**Biodiversity and Ecology
Planning Application Consultation Response Form**

<p>To : MCC Development Management DM Officer : Kate Bingham</p> <p>Planning Application Number: 2021/00323 Site: Twyn Cecil</p> <p>Proposal: Proposed detached bungalow - amended design to extant planning permission ref DC/2013/00703.</p> <p>Date of formal consultation: 15/03/2021</p> <p>Type: Pre app / Outline / Planning Application / Reserved Matters / NMA /Householder/Discharge of Condition</p> <p>Version of response: 1</p> <p>Biodiversity Officer : Stacey Delbridge Date of response : 11/05/2021</p>	
	<p>The Biodiversity Team, in responding to the above application, provides the following substantive response:</p>	
	<p>No comment</p>	
	<p>No objection - Subject to Conditions and Planning obligations</p>	
	<p>Holding objection - Further information or clarification is required</p>	<p style="color: green; font-size: 2em;">✓</p>
	<p>Objection – on the grounds set out below</p>	
	<p>Ecological considerations</p>

Proposed site block plan

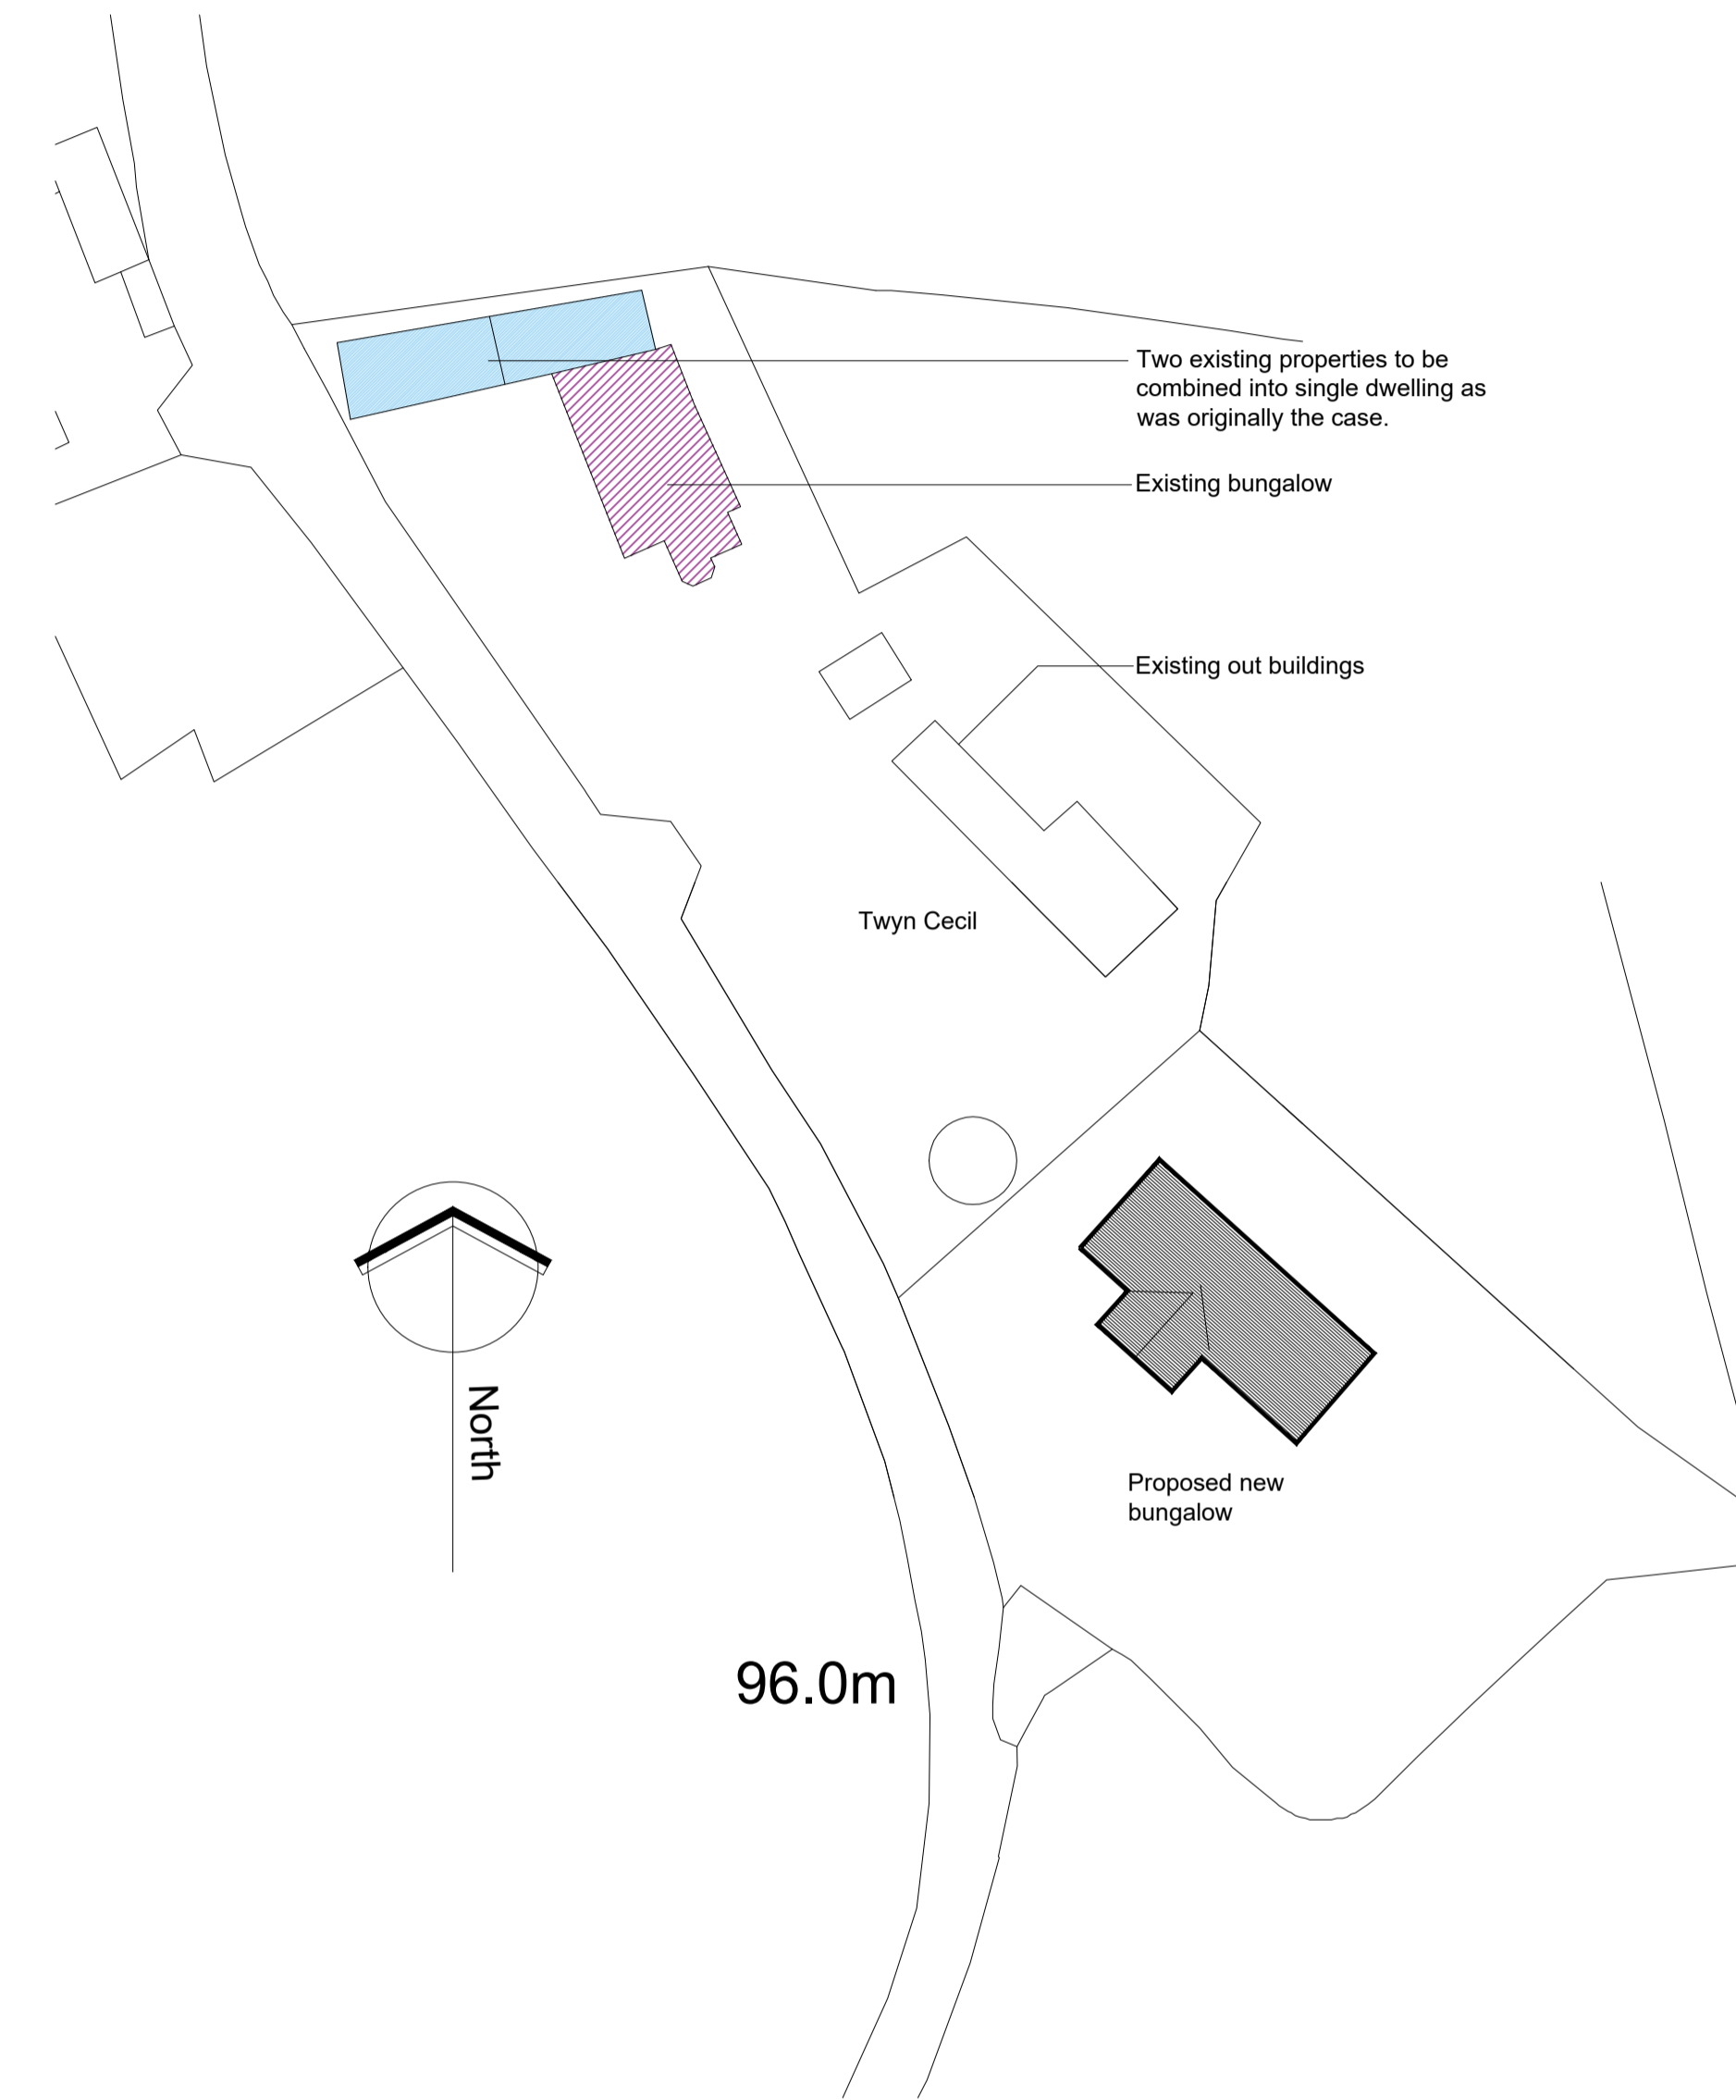
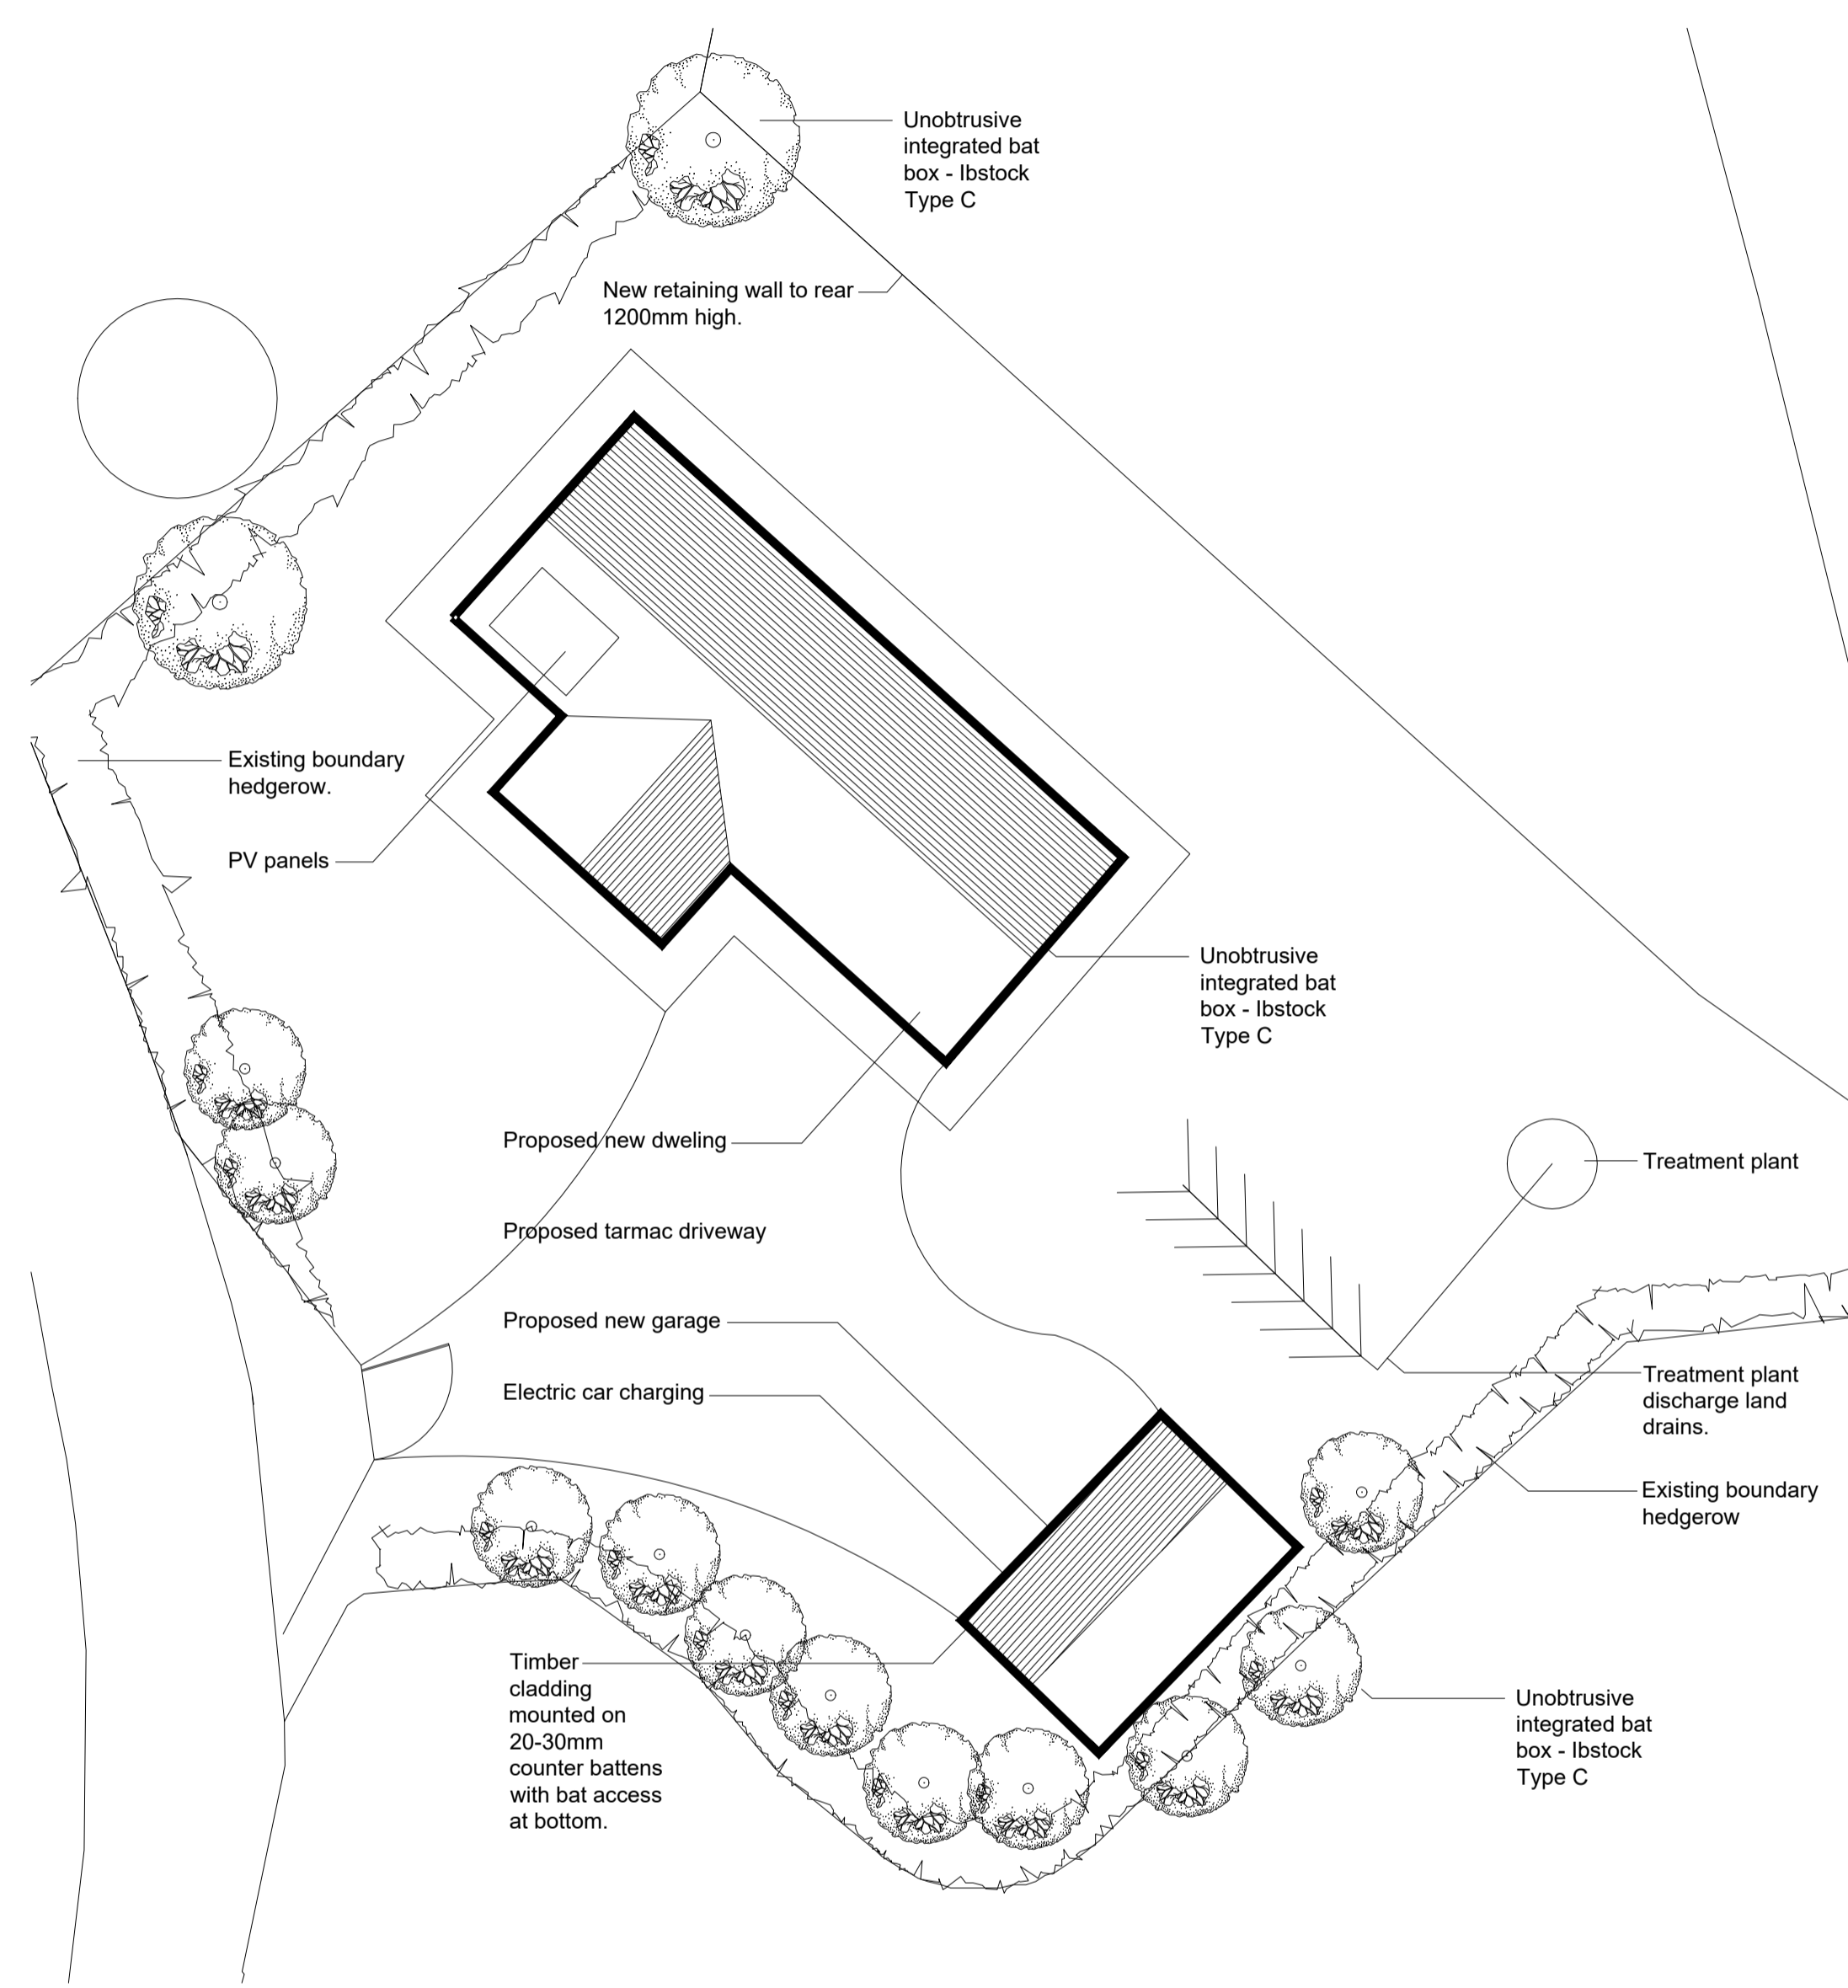
From review of the proposed and existing site plans and views on street view there appears to be a number of trees that will be removed to facilitate the dwelling and the garage. In accordance with Policy NE1 we would expect trees and hedgerows to be retained wherever possible.

We welcome the inclusion of bat enhancements, as was the requirement set out in the consent of 2013/00703, detailed on the site block plan. We have a few amendments/clarifications we would like to be addressed prior to determination.

-The type of bat box suggested on the tree at the northern corner and within the hedgerow are not appropriate, furthermore bat box installation in hedgerows is inappropriate, the applicant could consider bird boxes instead within this area, such as an open fronted robin/wren box.

North West elevation
1:100 Scale

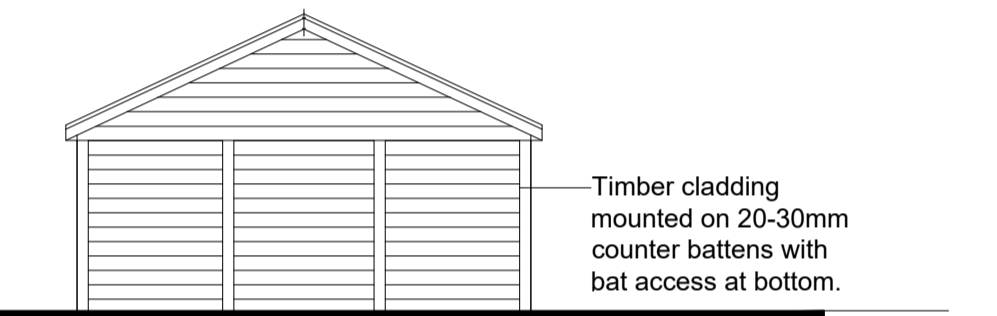
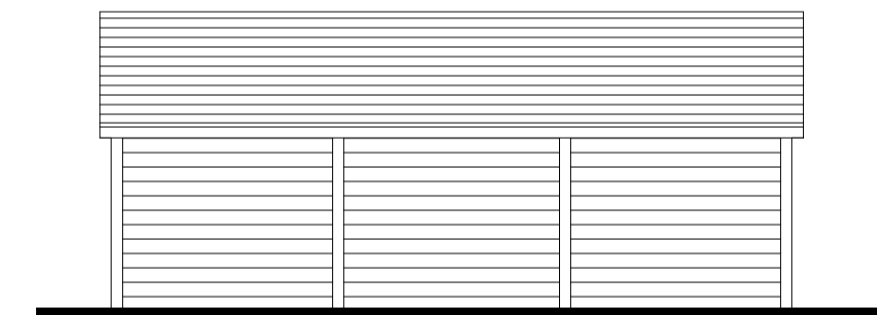
-Please could it be confirmed that the access provided on the garage will not allow access to any breathable membranes, only Bitumen Type 1F felt should be used where bat access is provided.

South West elevation
1:50 Scale

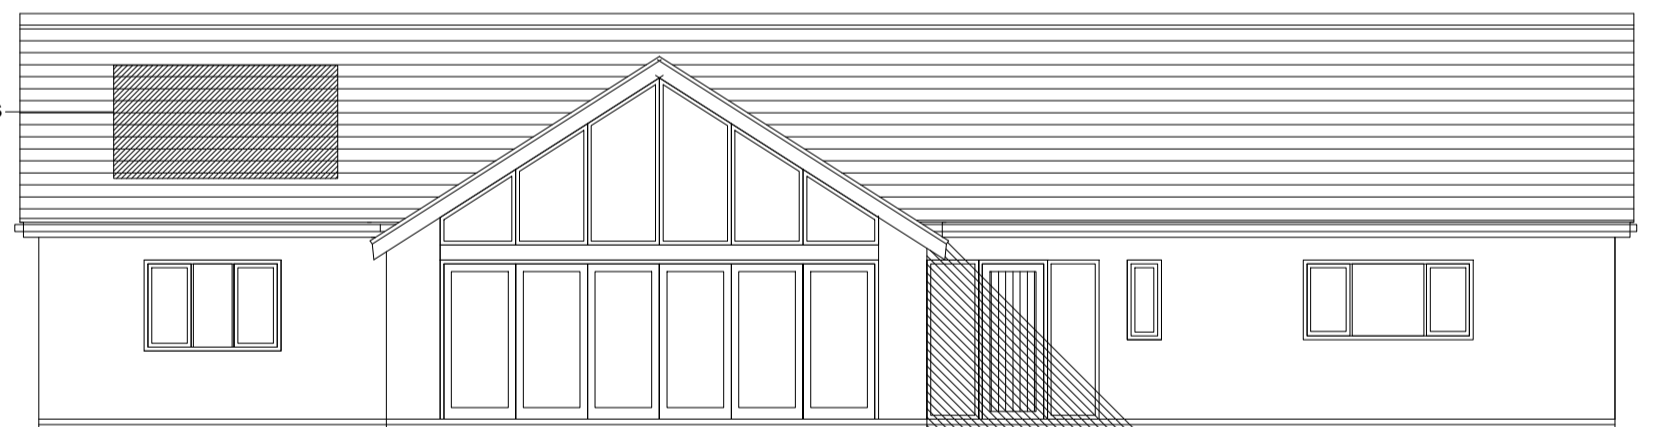
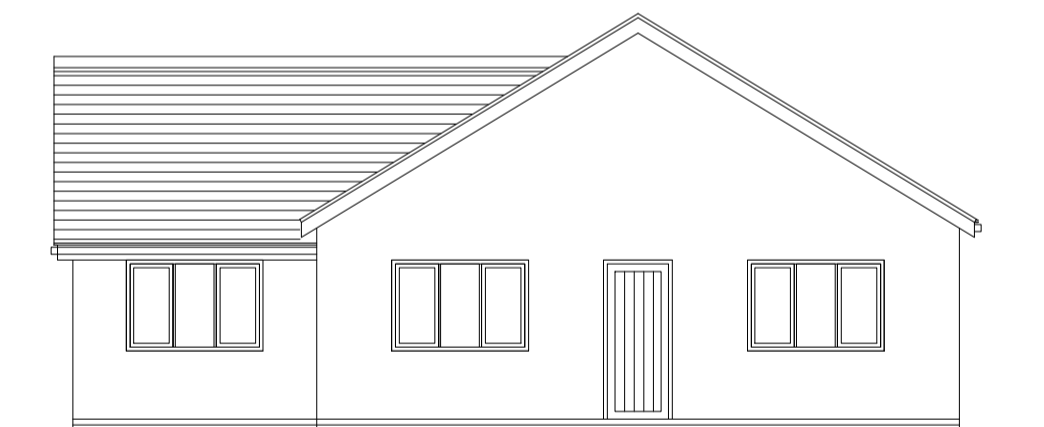
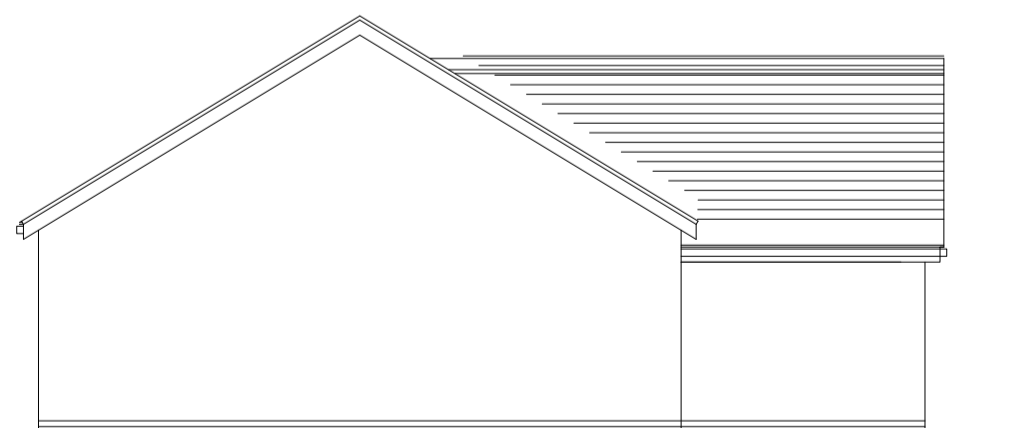
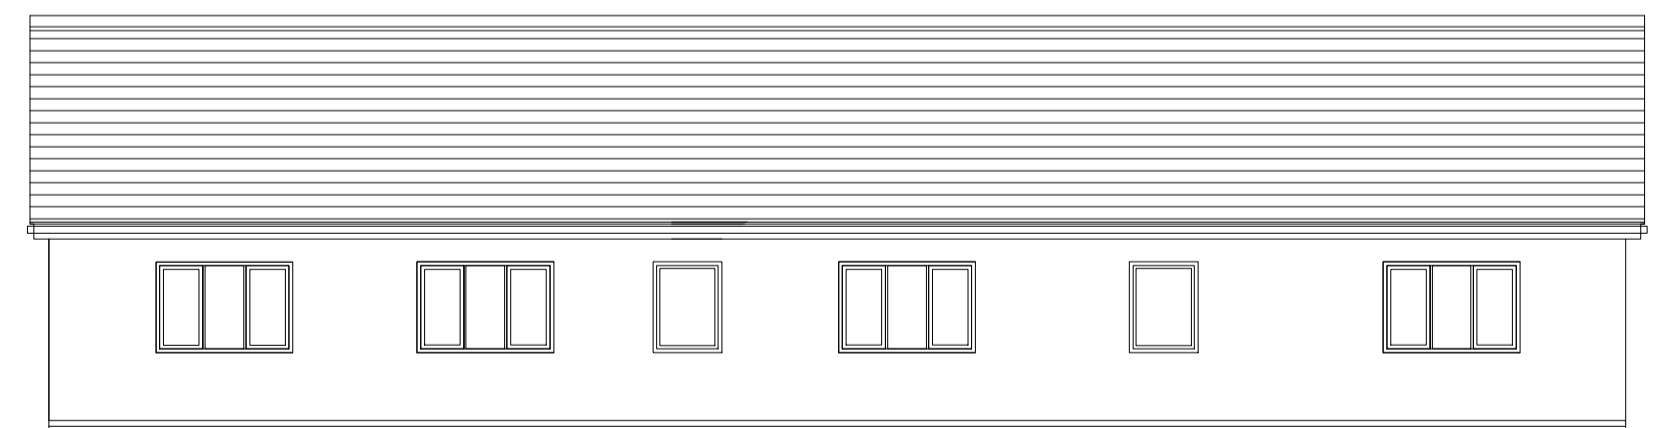
-Please could the bat box situated on the southern gable end of the property be marked on the elevation plans as per the counter batten annotation.
